KITTITAS COUNTY

MEMORANDUM

TO: All Staff
FROM: Public Works Plan Review Team
DATE: March 20th, 2024
SUBJECT: Public Works Comments: SP-24-00001 4G Farms

WALKER DRIVE SHORT PLAT
 PART OF SECTION 32,
 T. 18 N., R. 19 E., W.M.
 KITTITAS COUNTY, WASHINGTON

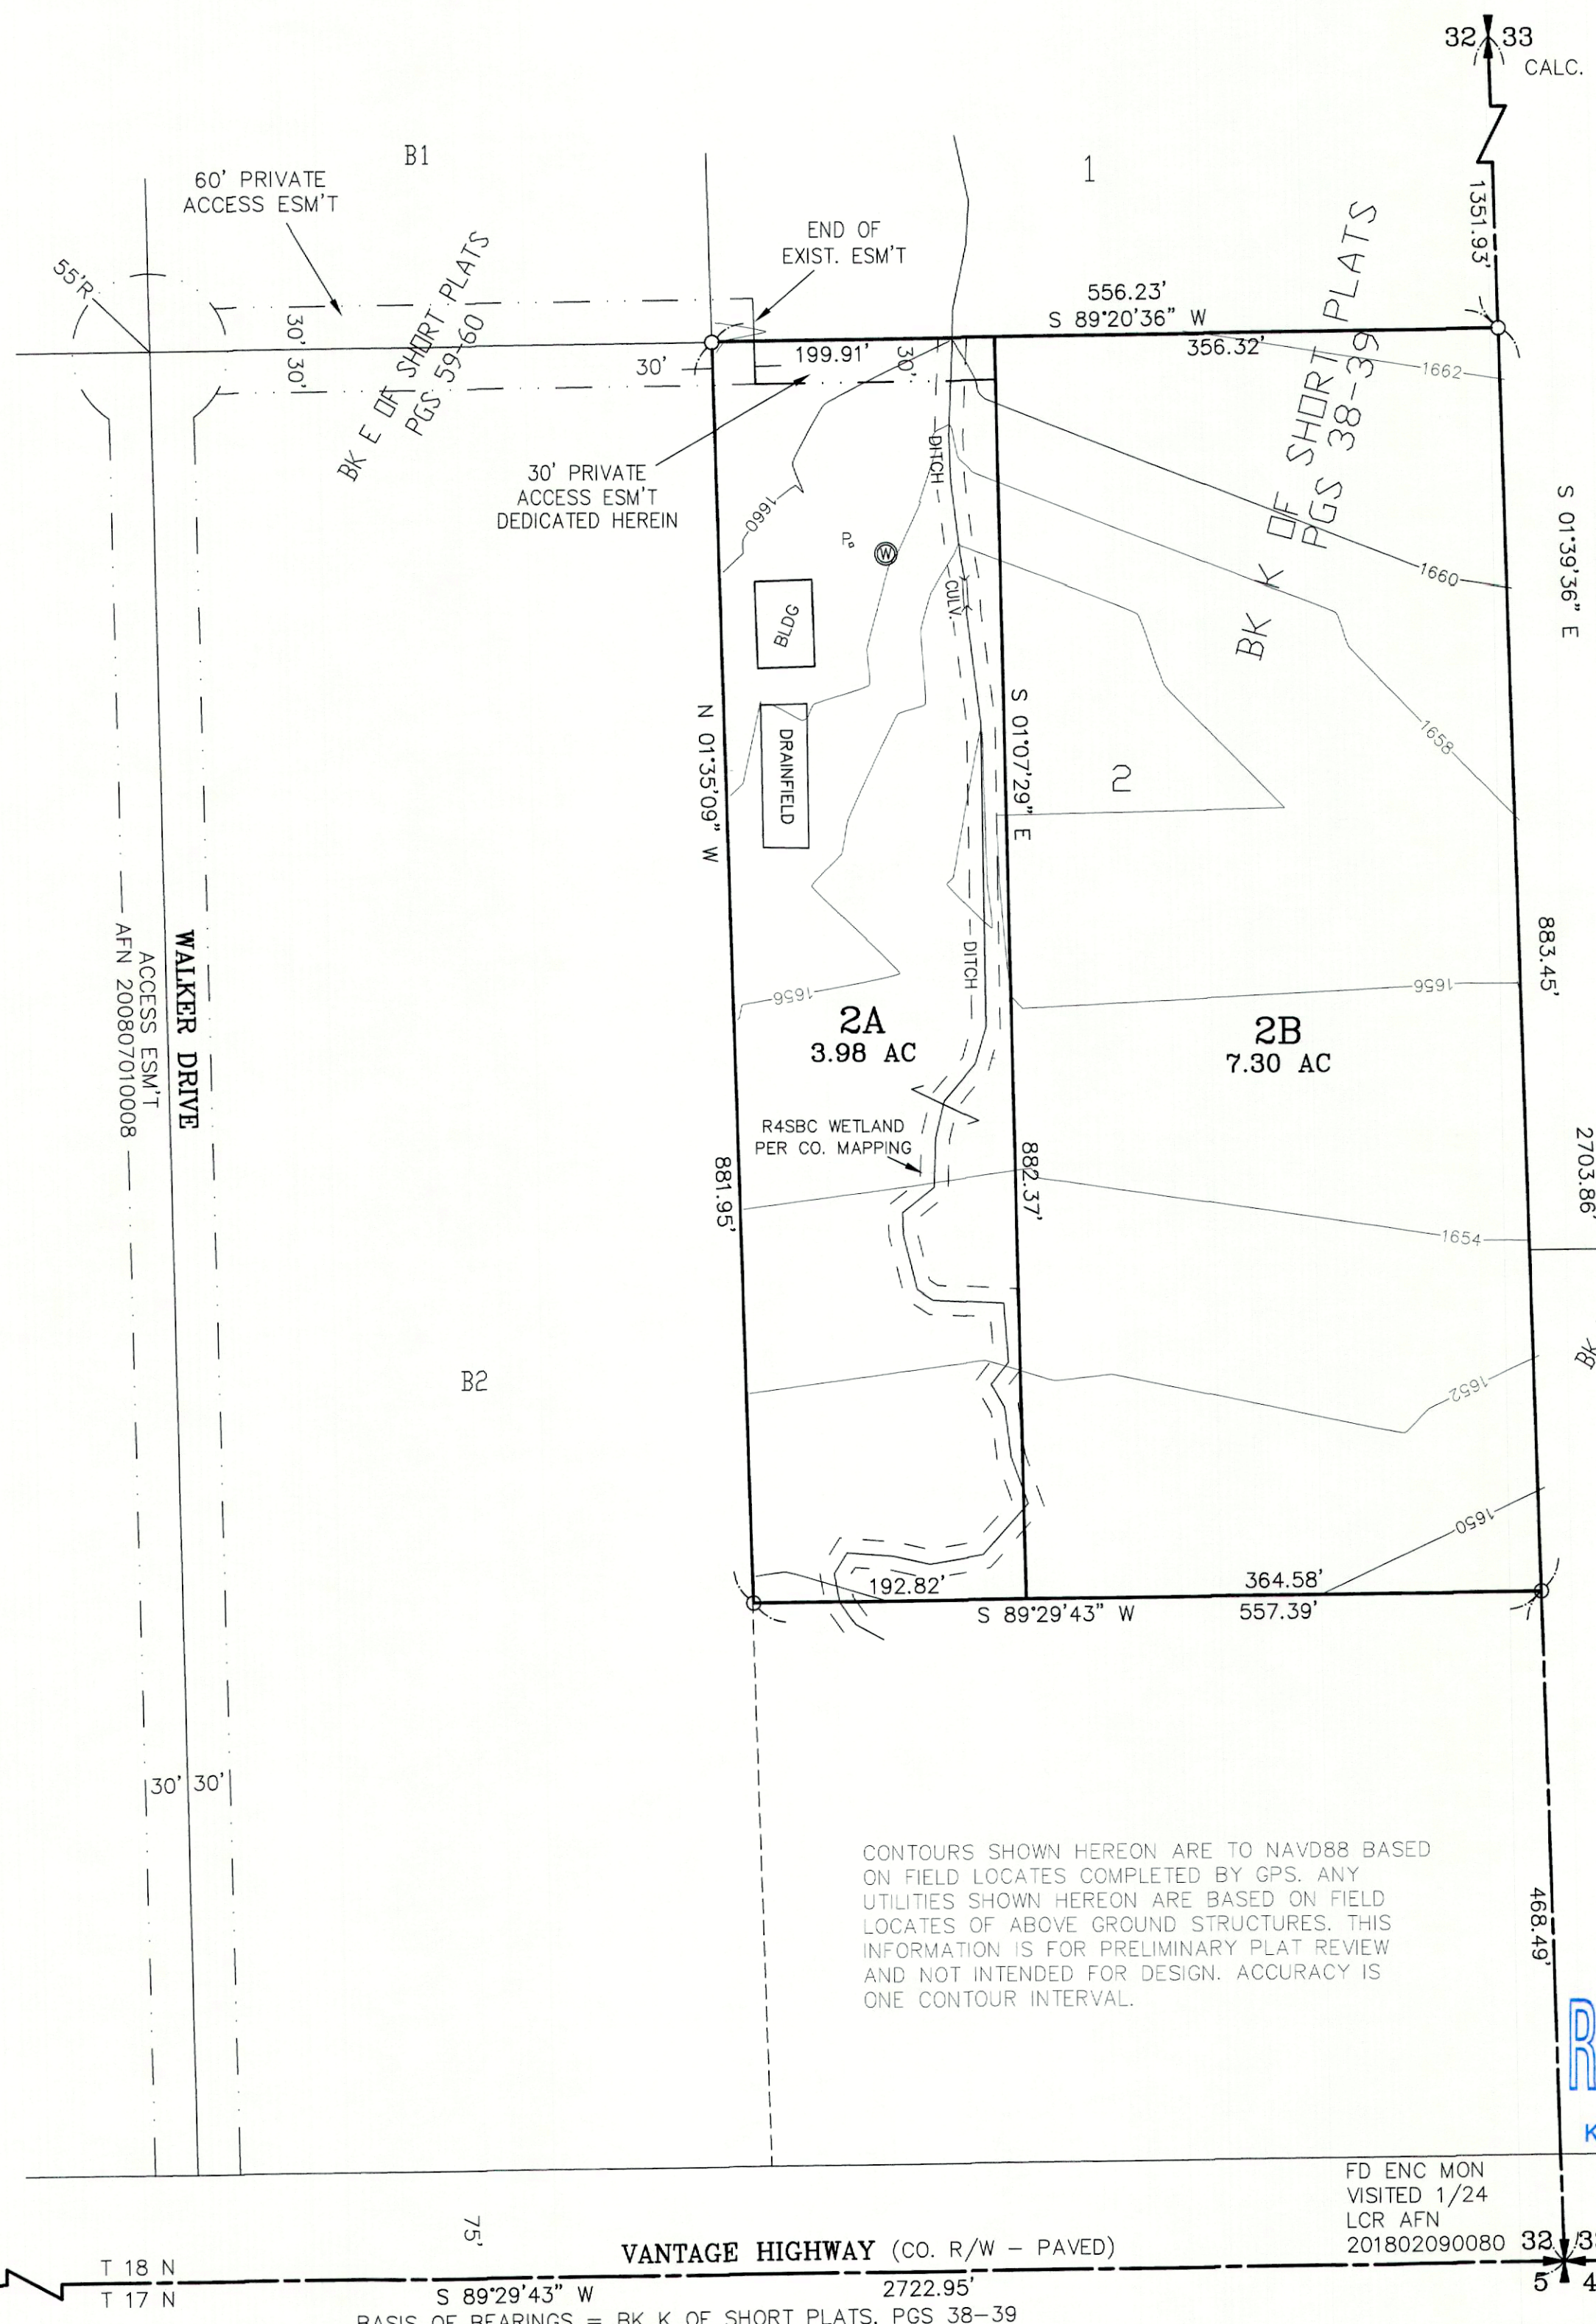
SURVEY	<p>Of note</p> <ol style="list-style-type: none"> 1. Easement from Walker Drive to property is unclear if it's a continuation of Walker Dr, an existing 60' easement or is to be created. 2. Found pin and cap but has no description for cap. <p>(KAH)</p>
TRANSPORTATION CONCURRENCY	<p>No transportation concurrency requirements for this project. (KAH)</p>
FLOOD	<p>Historic flooding data suggests that this property could be at risk of flooding. The current flood insurance rate maps (FIRMs) provided by FEMA do not reflect this risk. A flood permit is not required for the short plat. It is advised that any future development occurs on high ground away from the channel and that channel crossings are designed to be non-restricting to higher flows. (SC)</p>
WATER MITIGATION/ METERING	<p>The following comments outline the requirements for legal availability of water and metering for the proposed short plat:</p> <p>The applicant must provide legal water availability for all new uses on the proposed lots of this project, which can be provided through mitigation certificates. Prior to final plat approval and recording, the following conditions shall be met:</p> <p>In accordance with KCC Chapter 13.35.027, the applicant shall provide one of the following documents before final plat approval:</p> <ol style="list-style-type: none"> 1. A letter from a water purveyor stating that the purveyor has adequate water rights and will provide the necessary water for the new use; 2. An adequate water right for the proposed new use; or 3. A certificate of water budget neutrality from the Department of Ecology or other adequate interest in water rights from a water bank. <p>All applicants for land divisions shall also submit information on "proximate parcels" held in "common ownership" as those terms are defined in WAC 173-539A-030 and otherwise demonstrate how the proposed new use will not violate RCW 90.44.050 as currently existing or hereafter amended.</p> <p>Failure to obtain mitigation before commencement of an activity requiring mitigation shall be a code violation subject to enforcement under Title 18 KCC.</p> <p>Final Plat Notes</p> <p>The following notes shall be placed on the face of the plat:</p> <p>C-1 "Metering is required for all new uses of domestic water for residential well connections and usage must be recorded in a manner consistent with Kittitas County Code Chapter 13.35.027 and Ecology regulations."</p>
